WELWYN HATFIELD ACCESS GROUP
 Hazel Grove Community Centre
 hazel Grove
 Welwyn Garden City
 Hertfordshire AL7 2DG

Re: Planning Applications Received by Welwyn Hatfield Council

Appn No.	Description and Location	Applicant
S6/2010/0416/FP	Material amendments to planning approval S6/2007/0925/MA, to change one 2 bed standard house to a 2 bed house designed to DDA standards, together with external carport/canopy Land at Hazel Grove Primary School Hazel Grove Hatfield Hertfordshire AL6 9NR	Mr Roman Schmidt Canvas Architects Ltd Nickron House Bury Lane Rickmansworth Hertfordshire WD3 1DN

Title
**BLOCK E
 PROPOSED FLOOR PLANS**

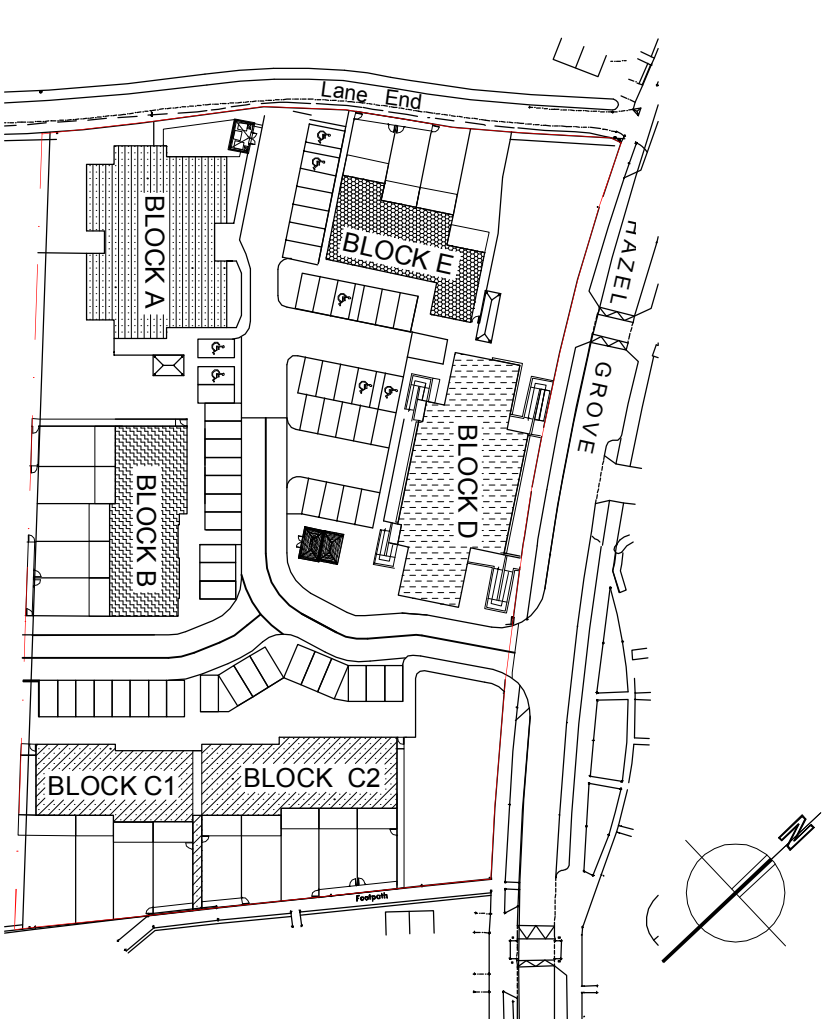
Could you please confirm whether or not the bedrooms and WC/shower rooms will have ceiling hoists as the peninsular layout of the WC's infers either a ceiling hoist or the availability of 2 helpers for transfer
